**From:** isobel.hartley@historicengland.org.uk  
**Sent:** 14 March 2025 17:19  
**To:** \_planningadvice  
**Subject:** Historic England advice on Application no(s) H23-0158-25  
**Attachments:** H23-0158-25\_HERef\_P01589312\_L466895.doc

**ST MARY'S CHURCH, KIRKGATE, WHAPLODE, PE12 6TA  
Application No. H23-0158-25**

The proposal seeks to replace the south aisle lead roof covering with terne coated stainless steel, due to failure of the existing lead roof covering causing water ingress in several places, plus its susceptibility to theft.

**INDICATIVE ROOF PLAN (SOUTH AISLE)**

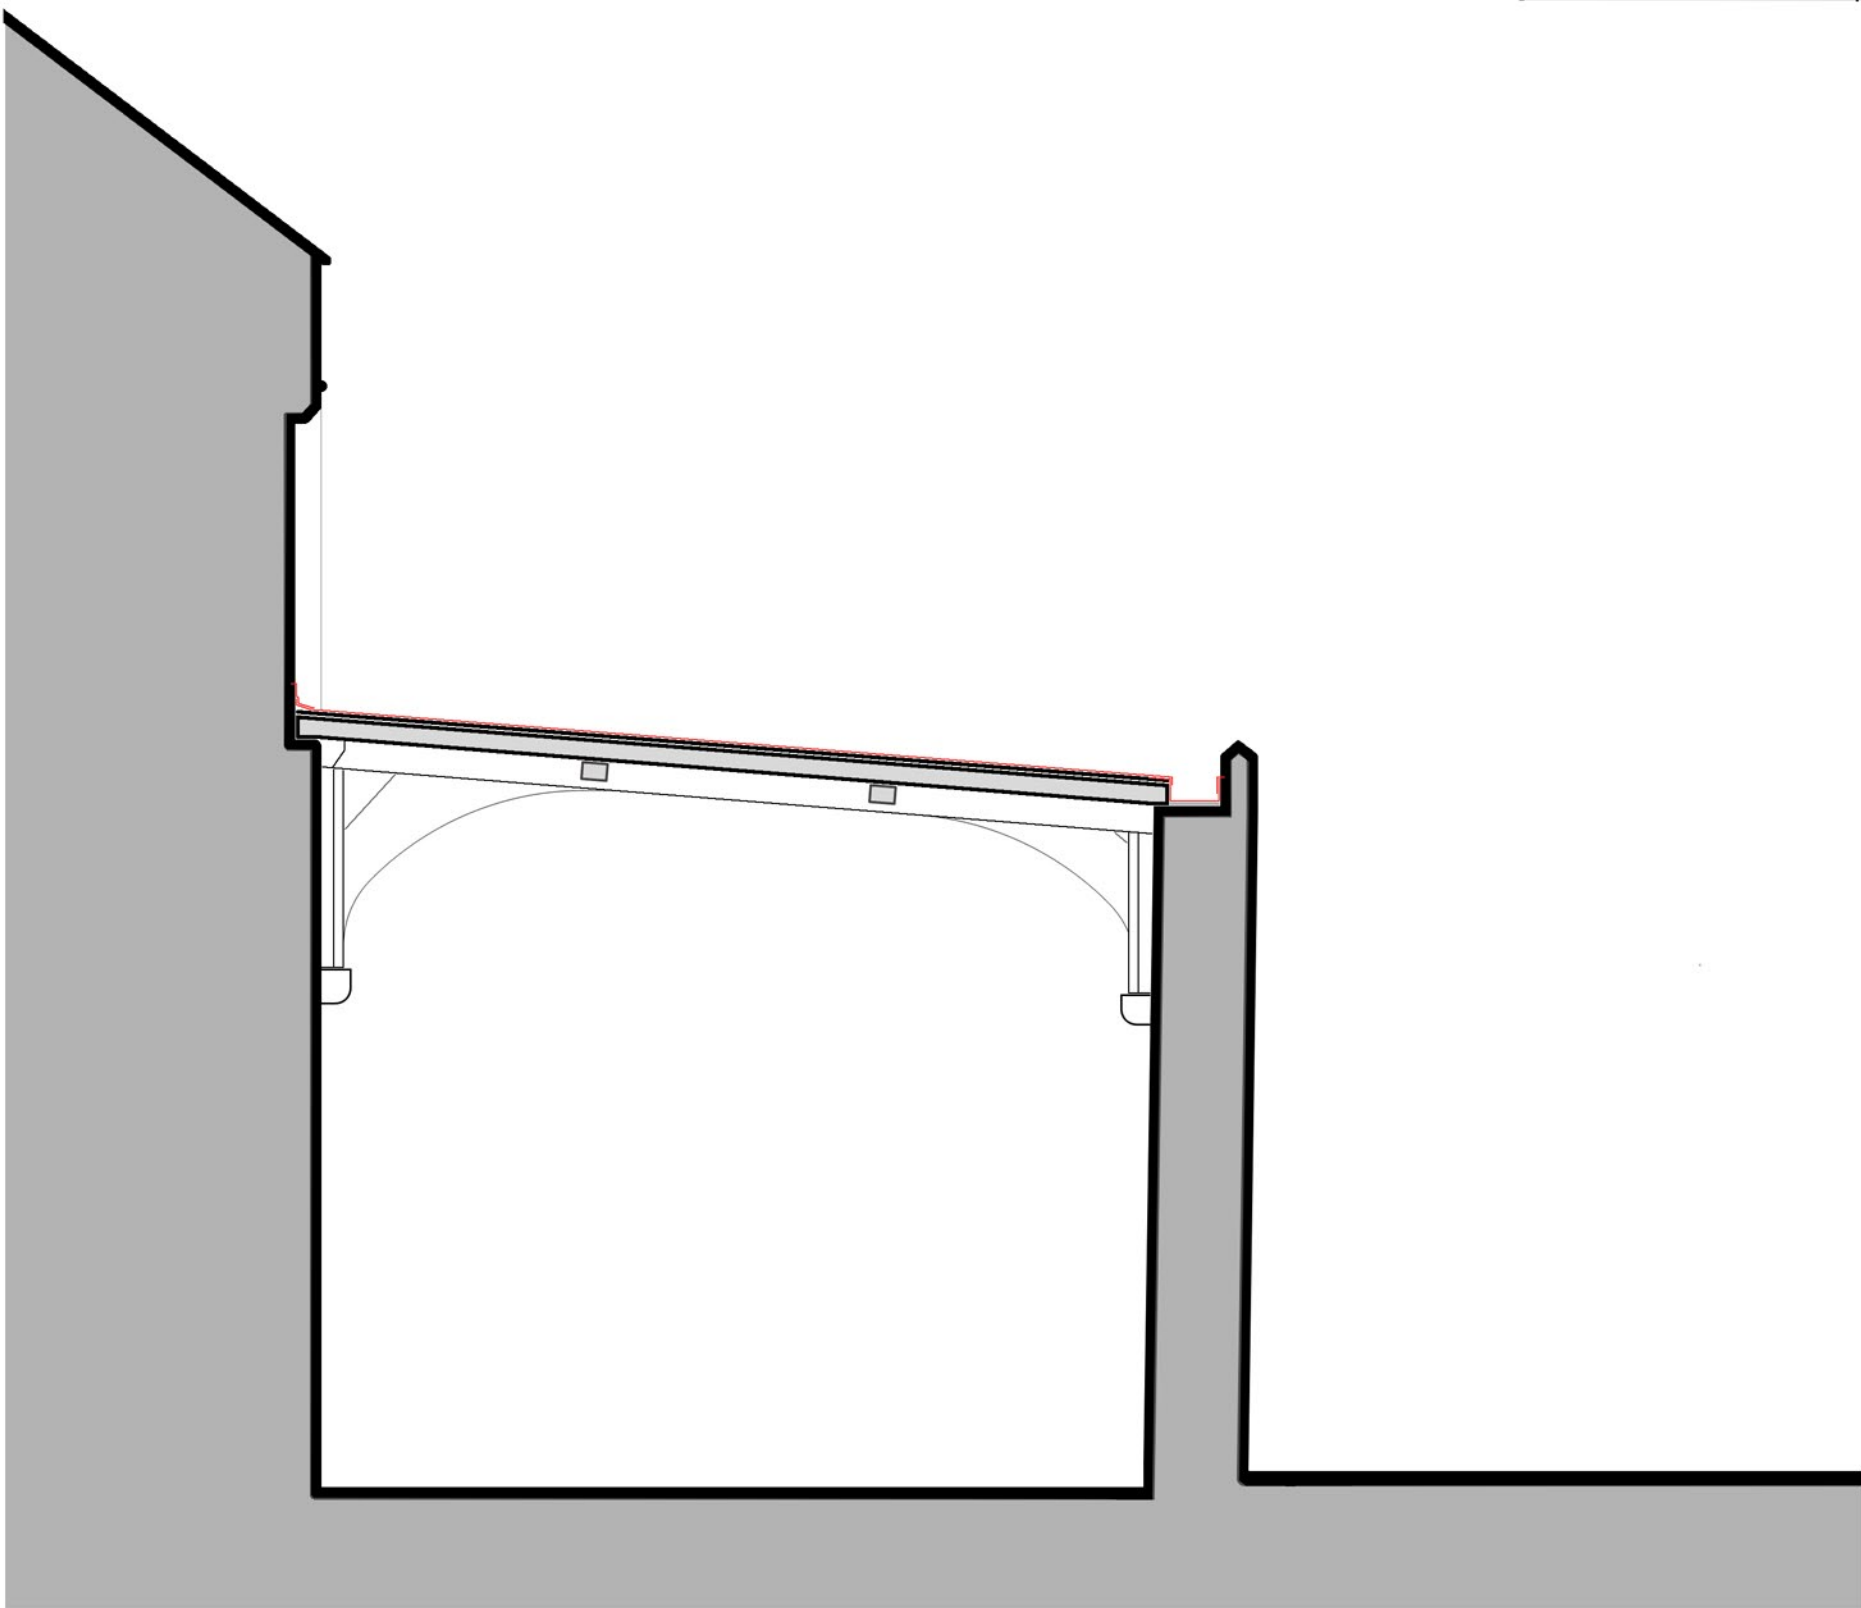
However, the submitted Heritage Impact Assessment refers to carrying out 'any necessary timber (and masonry) replacement and repairs' that are discovered in the process of removing the existing lead sheeting. If investigations reveal the need for works of this kind, full details would be required and should be provided prior to the commencement of any works.

TERNE COATED STAINLESS STEEL ROOF COVERING

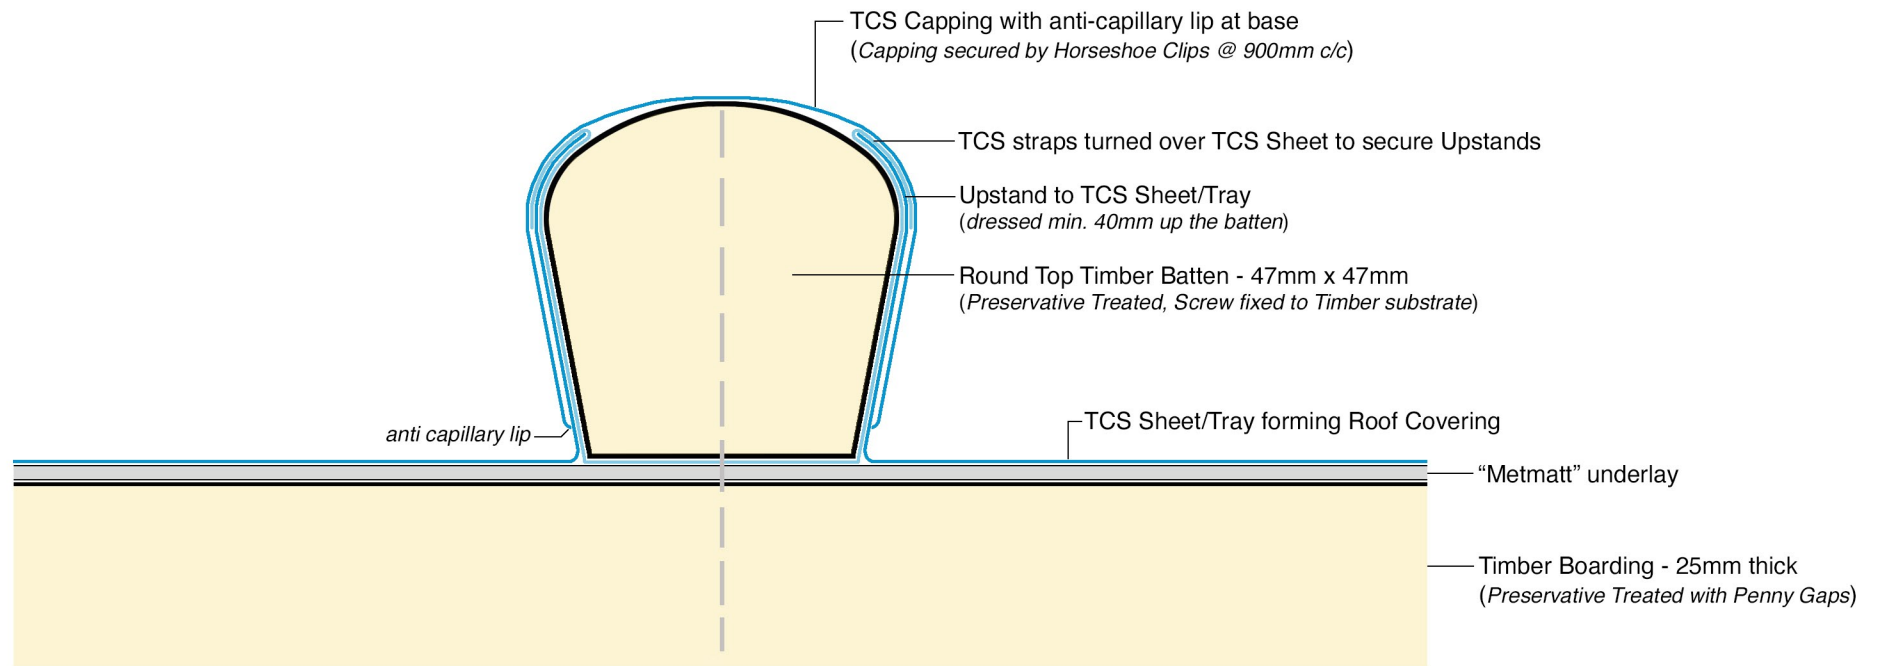
We consider that the application for the replacement of the south aisle roof covering with terne coated stainless steel meets the requirements of the NPPF, in particular paragraph numbers 210, 212 and 213 by preventing further water ingress.
